Subject: Balloon Framed Wall Issue
00 Anderson Creek School Rd.
Bunnlevel, NC 28323
JDS Consulting Project No.: 25902255
Review Date: 07/24/2025

The client requested verification of the balloon framed wall design per detail 1 on sheet S-1 of the provided plans (AHP job no.: 141-25-008, dated 06/19/2025) for the Johnson residence located at the above address.

① FRONT WALL FRAMING DETAIL
1/4" = 1'-0"

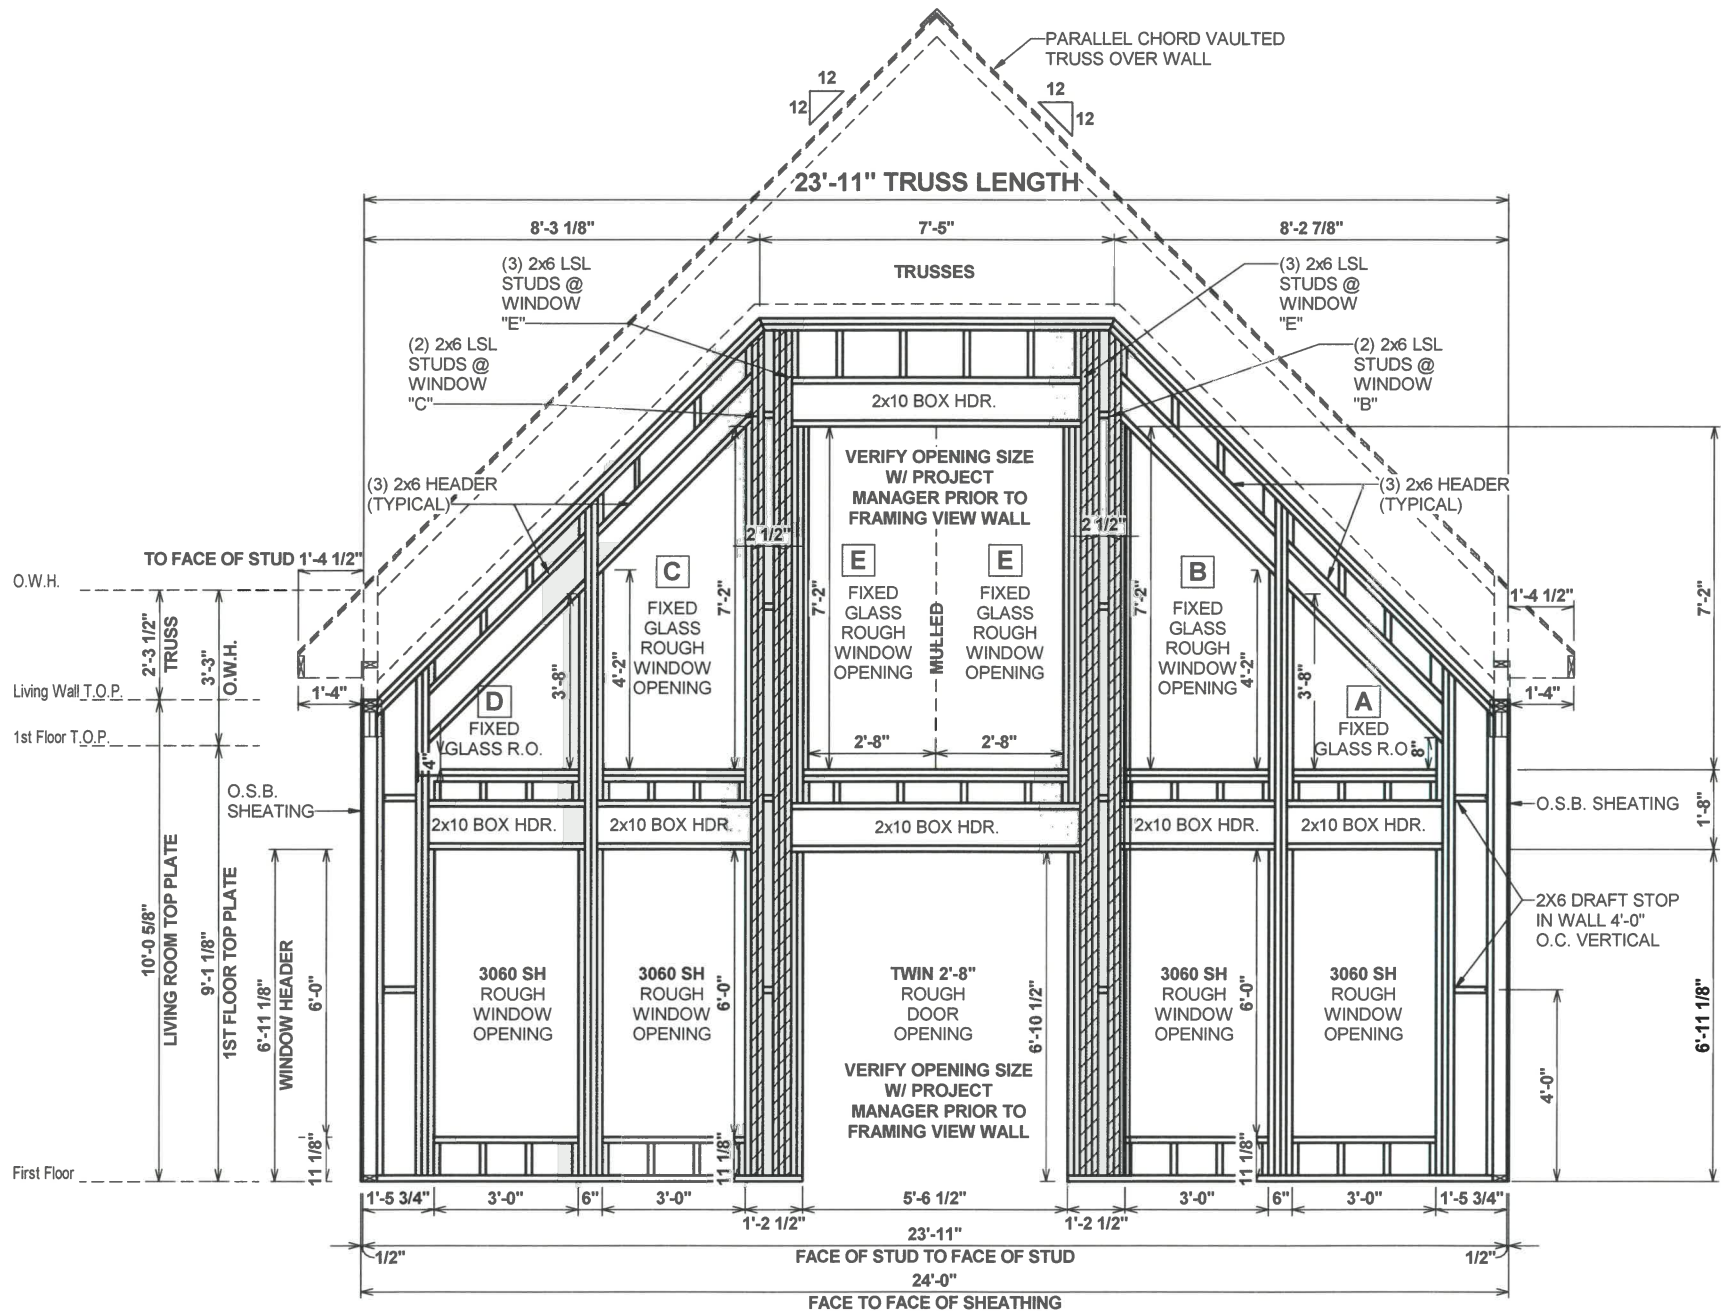
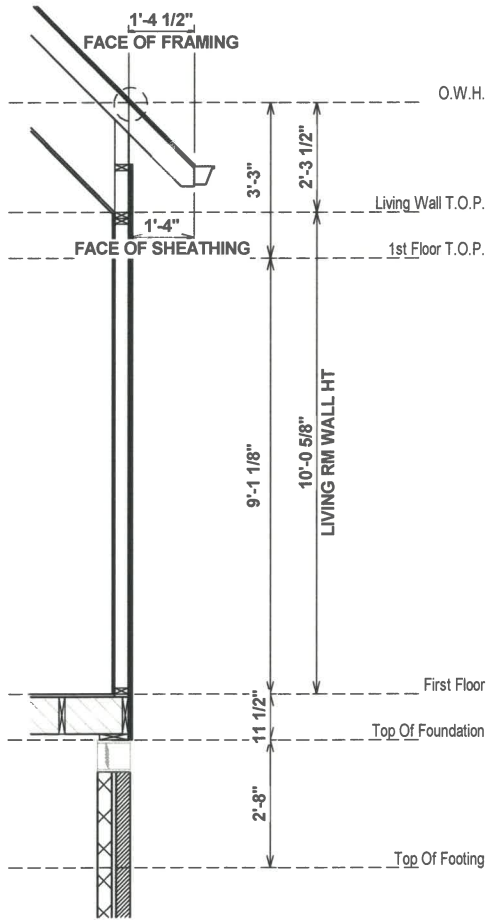
Based on our review, the balloon framed wall as specified in the referenced plans is sufficient to support the design loading conditions given the changes noted in the revision clouds shown on page 2.
